From: [Kelly Bacon \(CD\)](#)
To: [Holly Erdman](#)
Subject: RE: Notice of Application - CU-20-00003 Carey
Date: Wednesday, September 30, 2020 3:03:10 PM

Kittitas County CDS is requesting comment on the Conditional Use application CU-20-00003 Carey Mini warehouses.

The proposed project would establish 9 mini warehouse facilities. All application documents can be found at the links below. I have also attached the SEPA Checklist for recording. Please let me know if you have any issues accessing the materials. Comments are due for this application by 5pm on September 30, 2020. If CDS does not receive comments by this date, we will assume your agency has no interest in the application.

# Site Plan

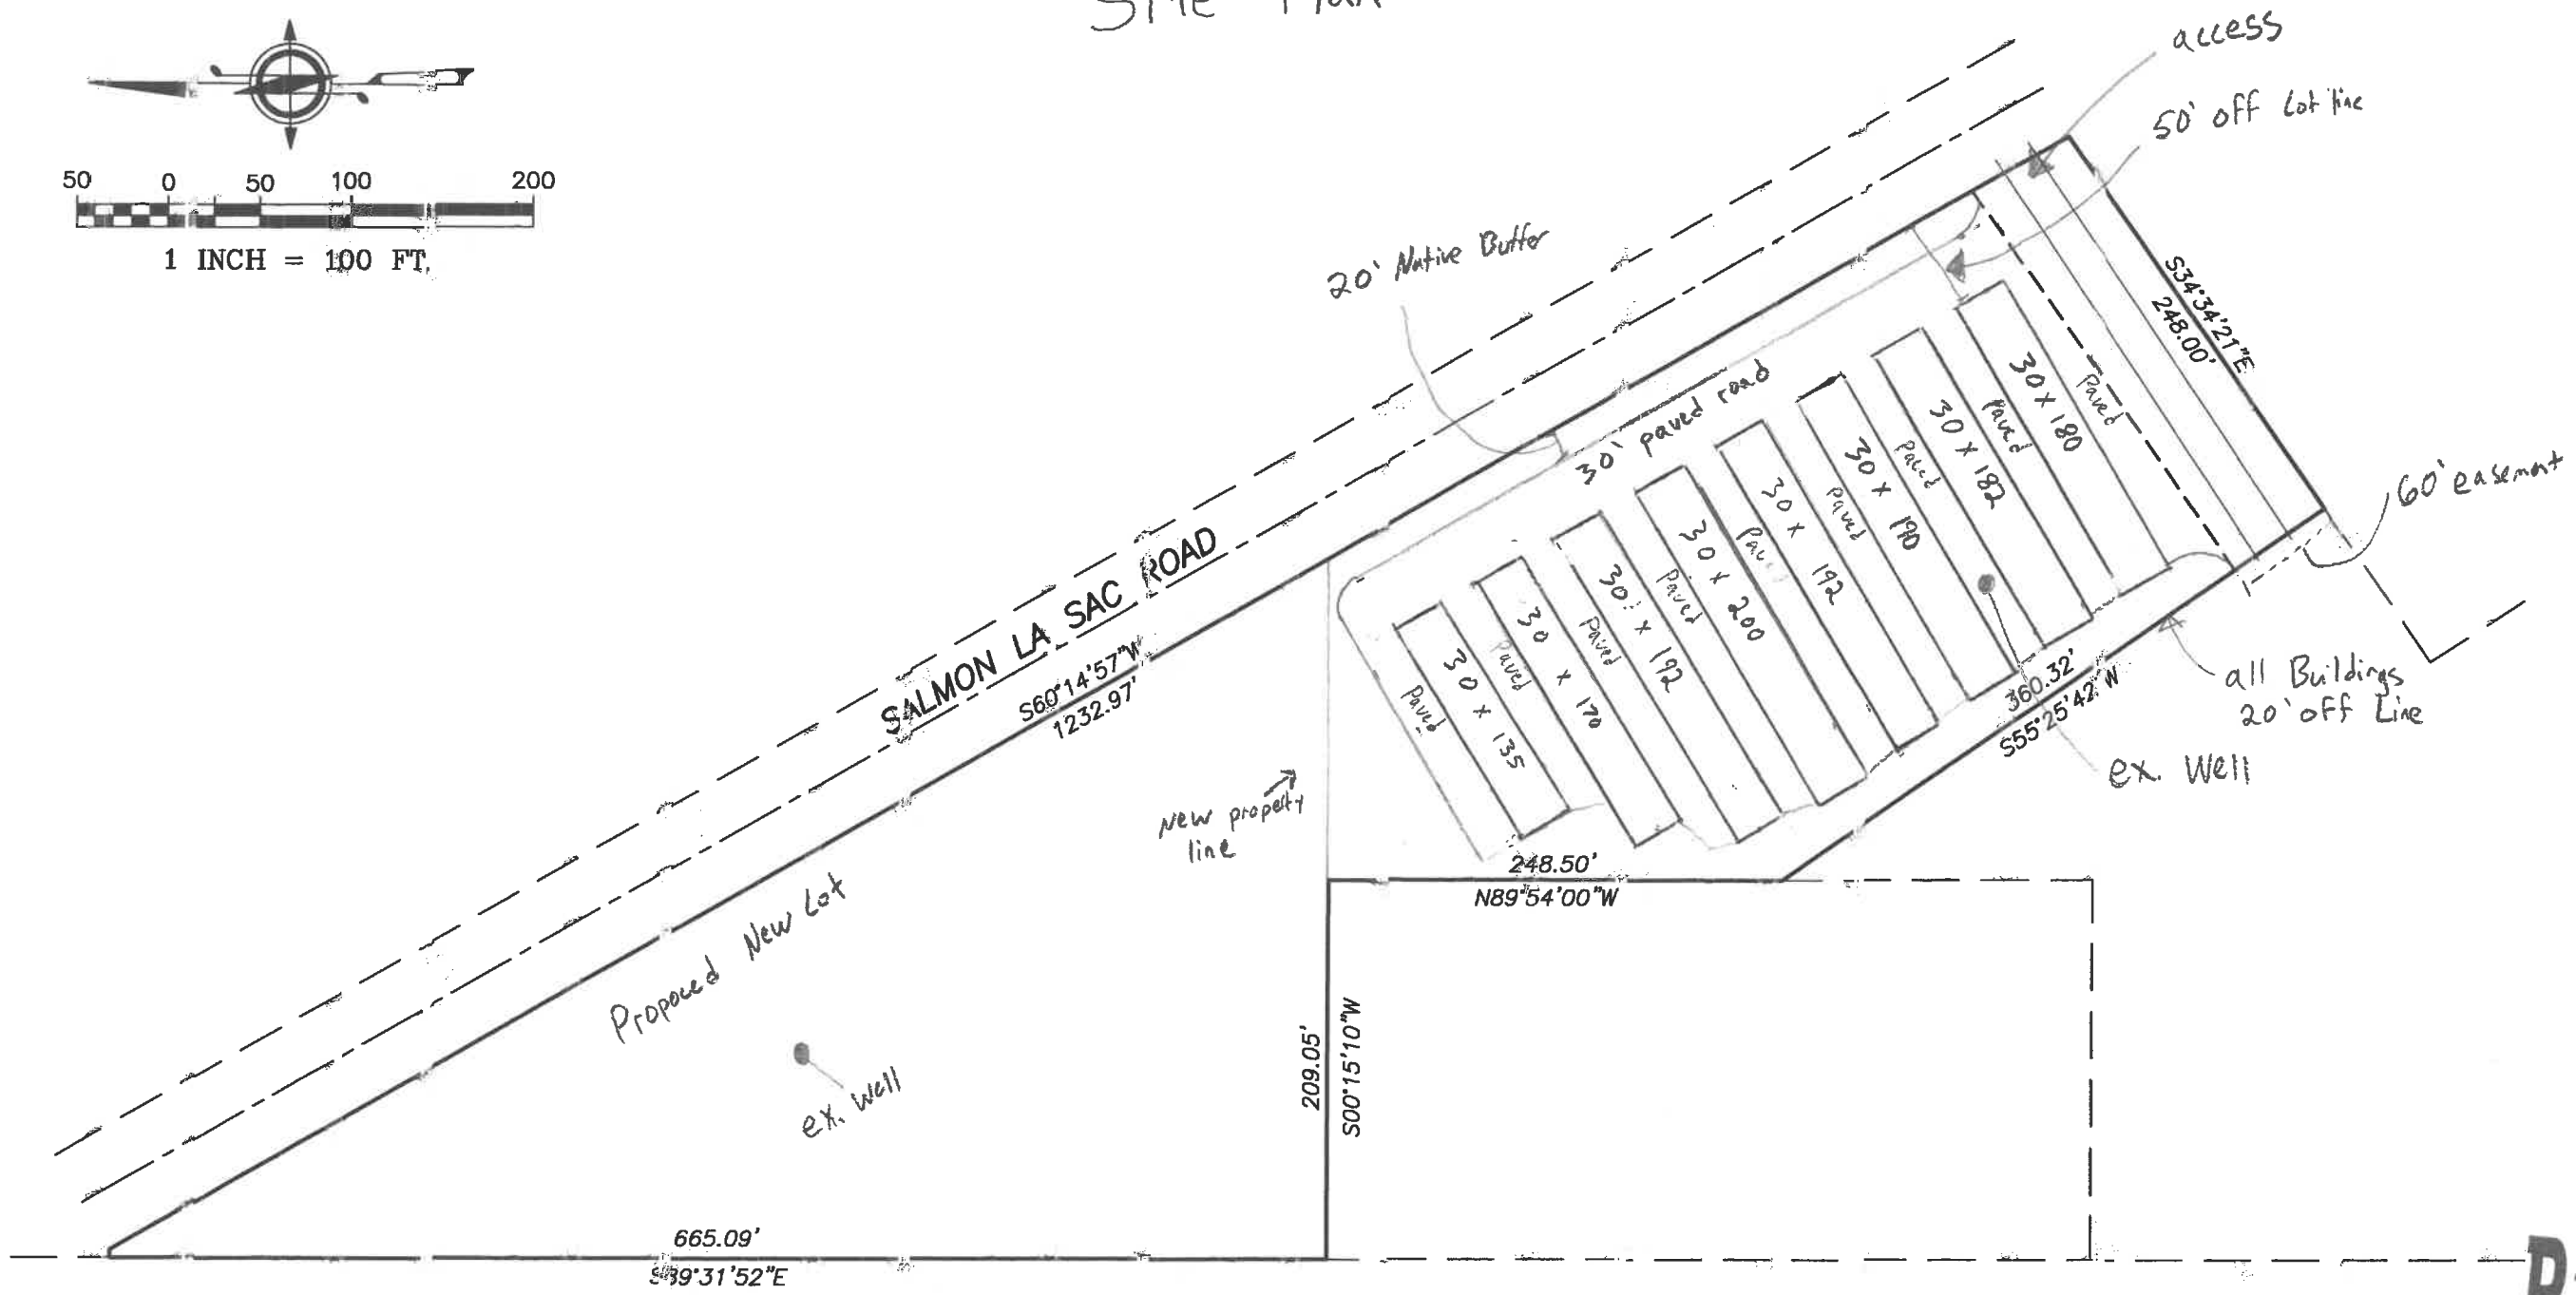
I see comments on this are due today. The site plan shows 2 existing wells. Are there any structures with water to them proposed for this project? They indicate in the application that there will be an individual well but I don't see where it will be put to use. Any additional information would be helpful.
